Trinity Grammar School Redevelopment (SSD 10371)

I refer to the State significant development application for the Trinity Grammar School Redevelopment (SSD 10371) (**Project**), currently before the Independent Planning Commission for determination.

Attachment A – Applicant Information

# Junior School Play

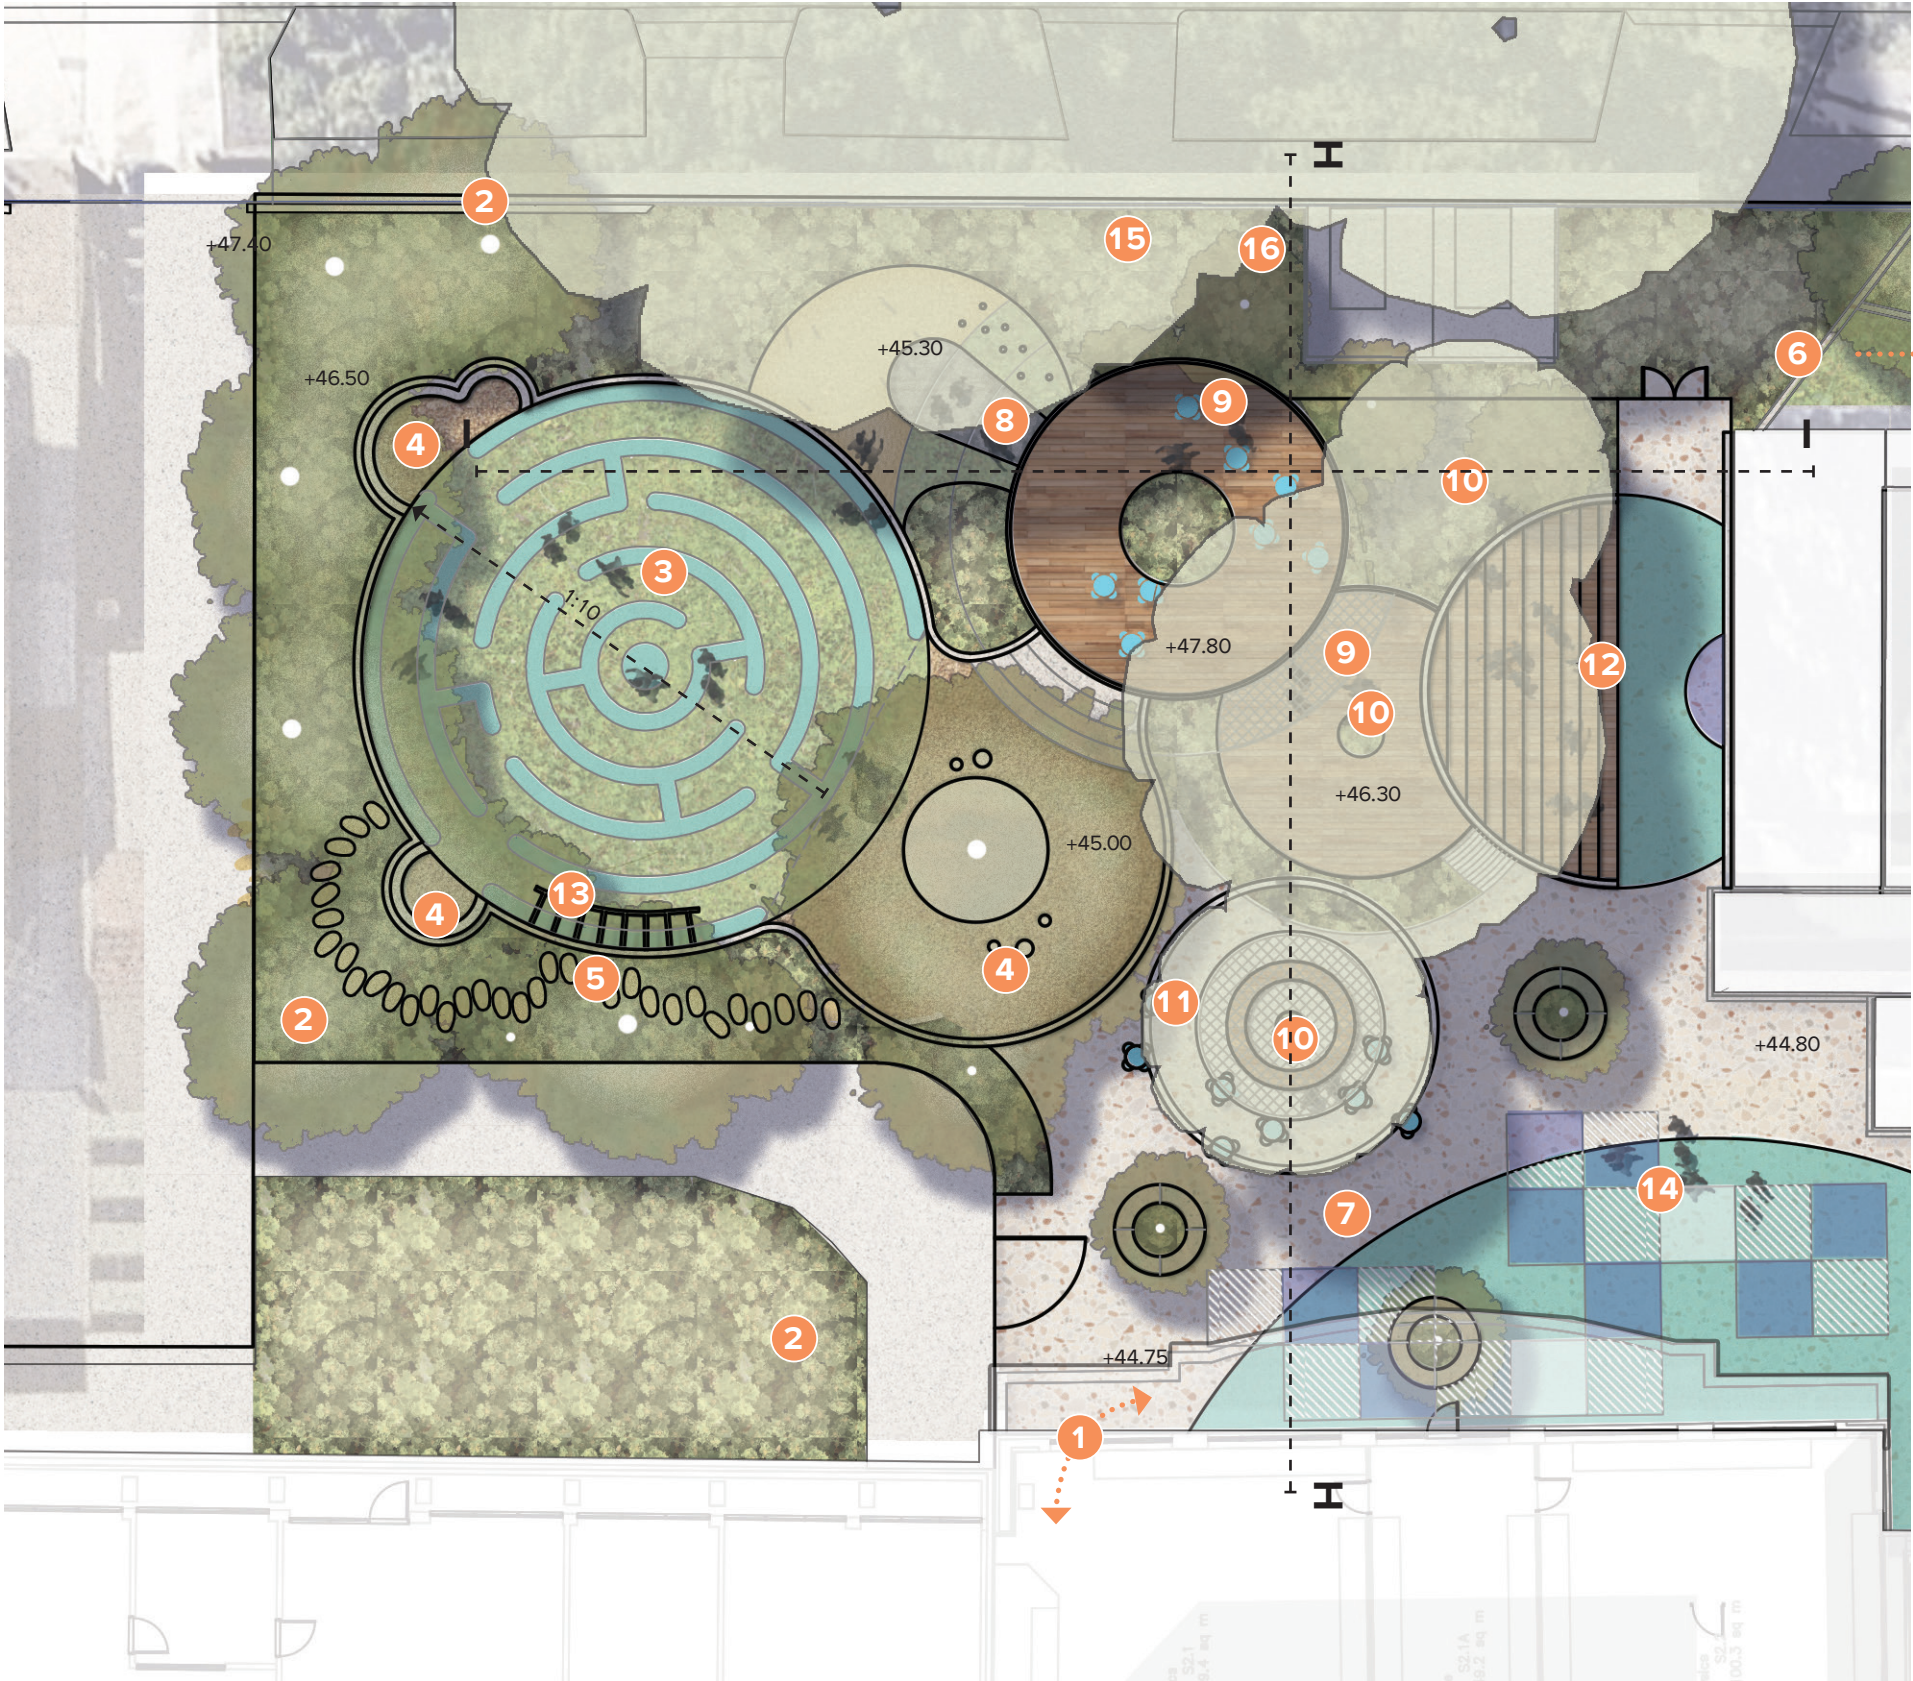
12. Explanation of Section I-I on Junior School Play area (landscape drawings).
13. Details of planting bed construction, including soil depths.
14. A comparison prepared by the Applicant's heritage consultant of the design of the existing buildings and the Project's proposed design, as discussed at the Applicant's meeting with the Commission on 11 August 2021.

JUBILEE ARRIVAL

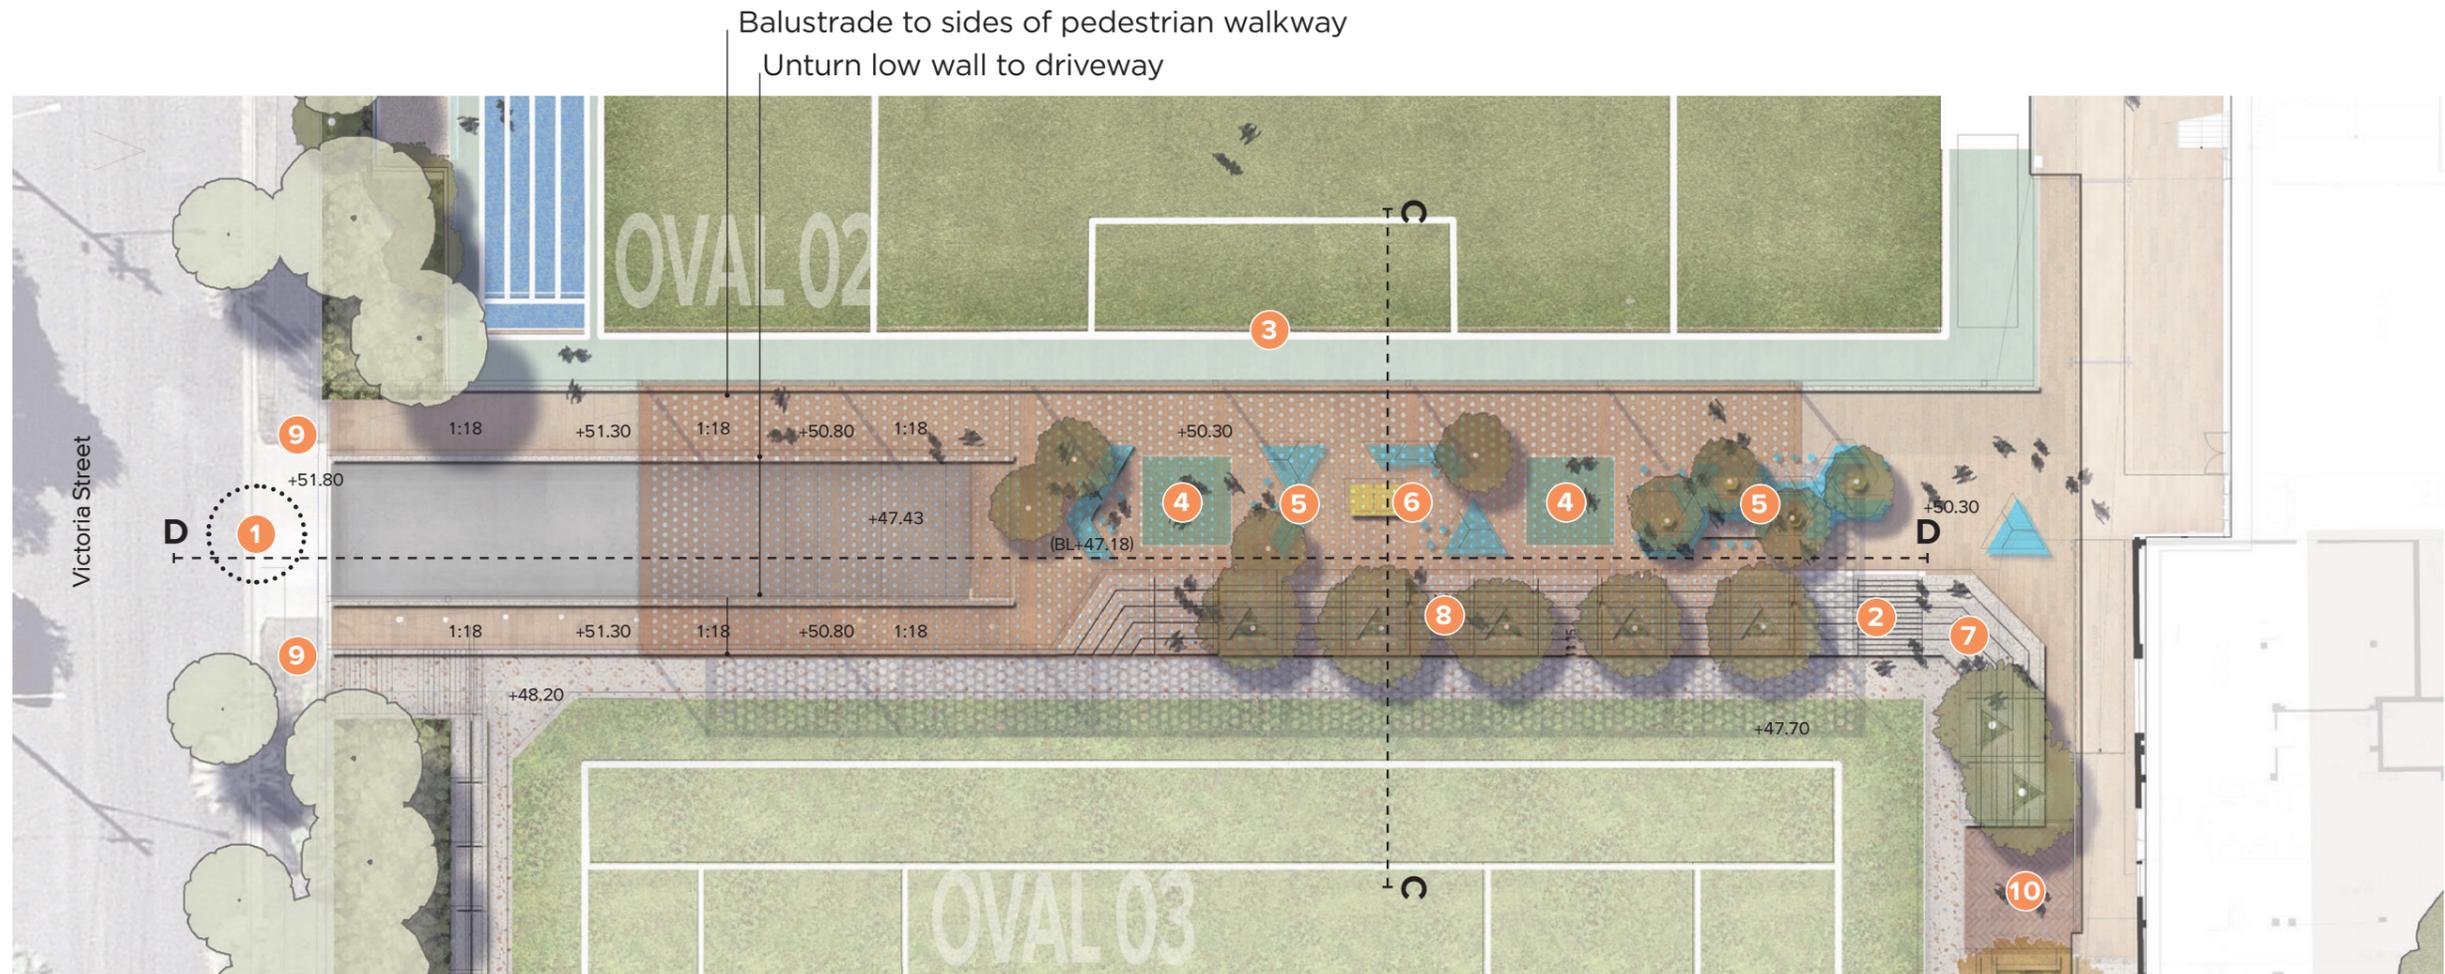
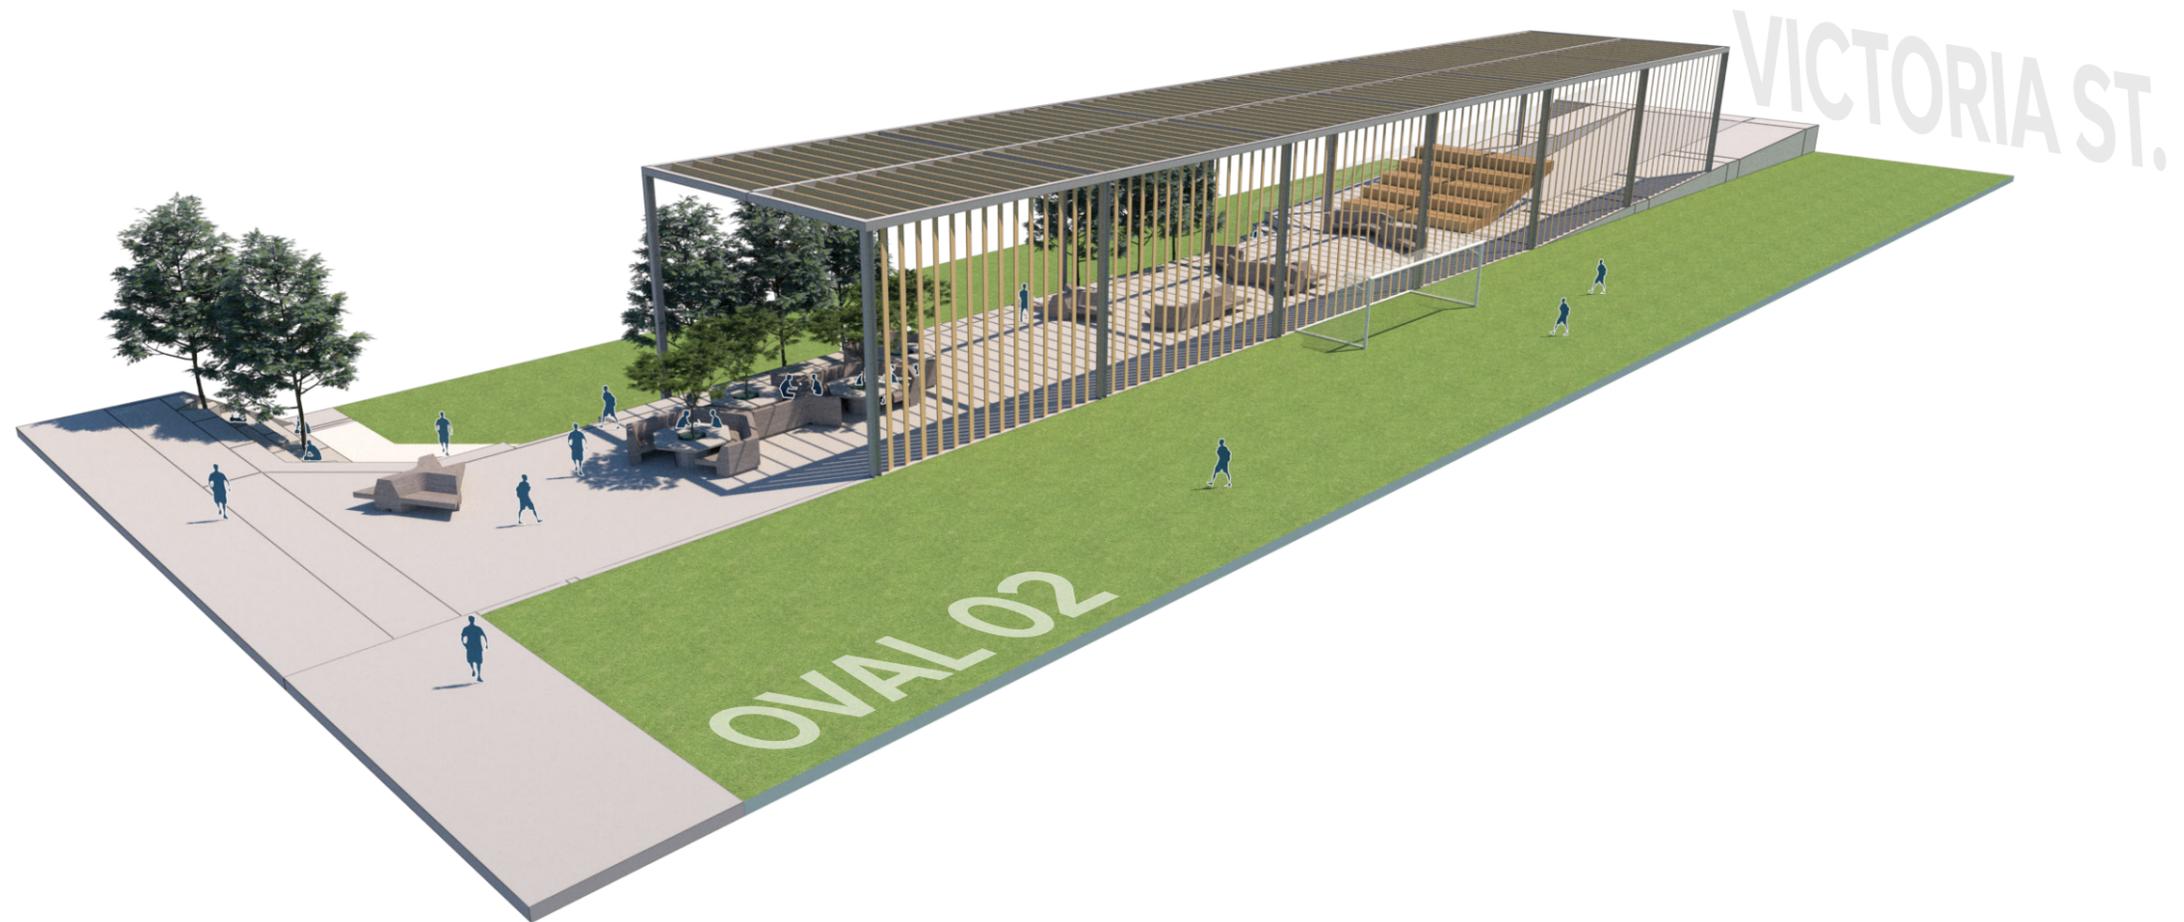
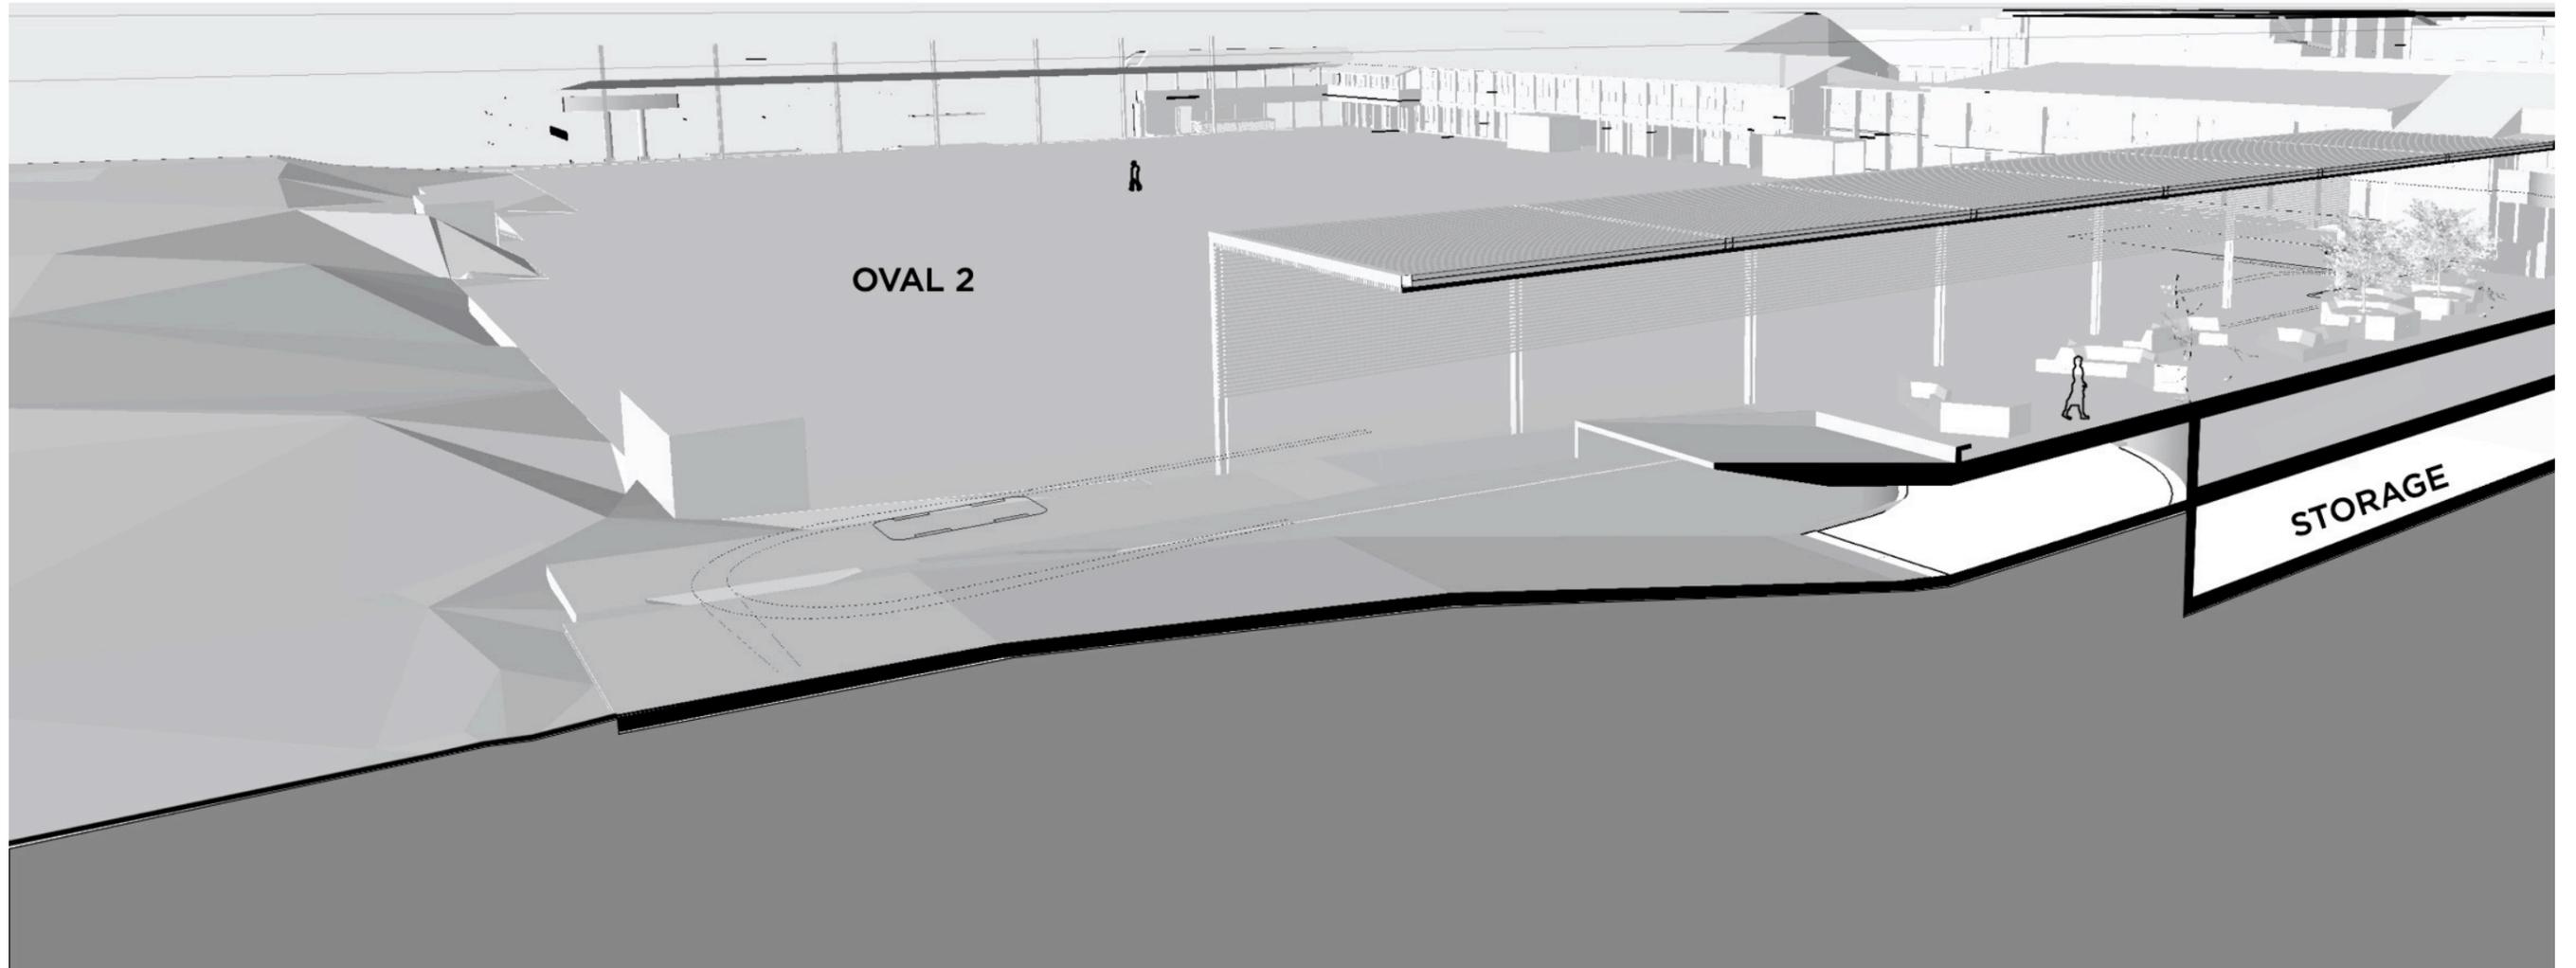
7. Details of the new Jubilee entry: cross sections and long section (at a scale no less than 1:200) of the proposed Jubilee entry, including RLs, connections to adjacent playing fields, schematic barriers required by all relevant codes, proposed landscaping and all proposed structures along the full length of the Jubilee entry.
